**SUBMISSION TO THE DEPARTMENT OF PLANNING AND INFRASTRUCTURE ON THE PROPOSED
NORTH WEST RAIL LINK (NWRL)**

Application Number: SSI-5100

Figure 6.11 Cheltenham Services Facility light vehicle access and egress

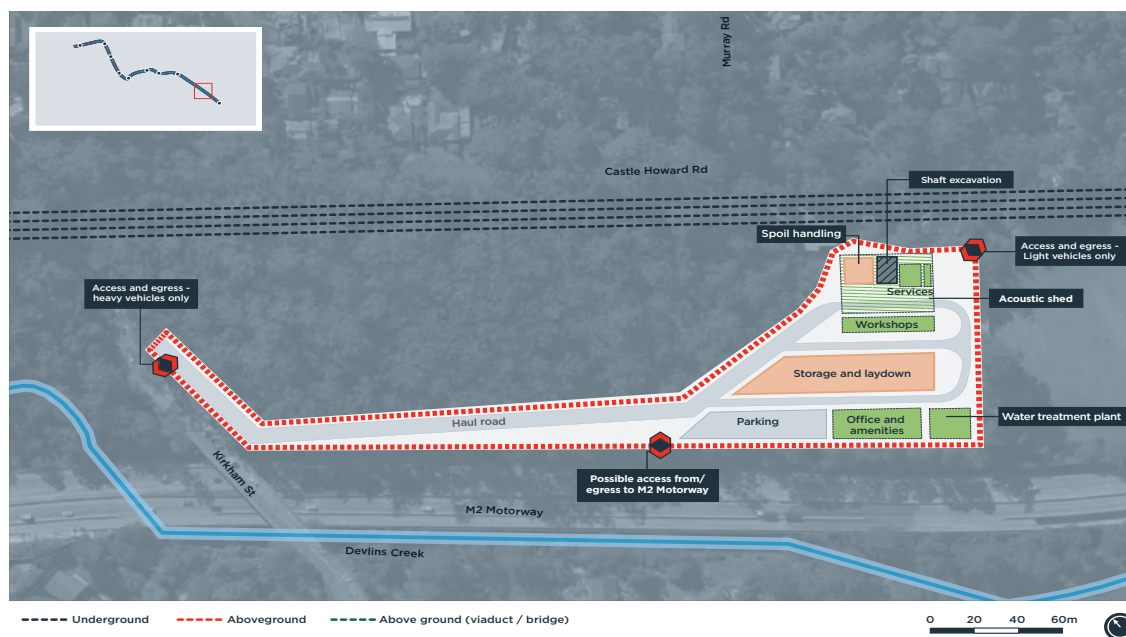
1. The option to construct a new two lane paved road through the Castle Howard Conservation Reserve to Kirkham Street (or Castle Howard Road) near the bridge over the M2 to allow trucks to remove spoil during construction and light vehicle access during operation of the facility will permanently destroy valuable Blackbutt Gully forest.

I therefore ask that you adopt the alternative option of access to the site for construction and emergency vehicles be via new on and off ramps from the M2 motorway. The current widening and reinstatement of the breakdown lane should allow this access. It is the only practical way to move trucks in and out of the site. In the event of an emergency, many emergency vehicles would need quick access to the site from areas outside Beecroft and Cheltenham as it only has one fire engine.
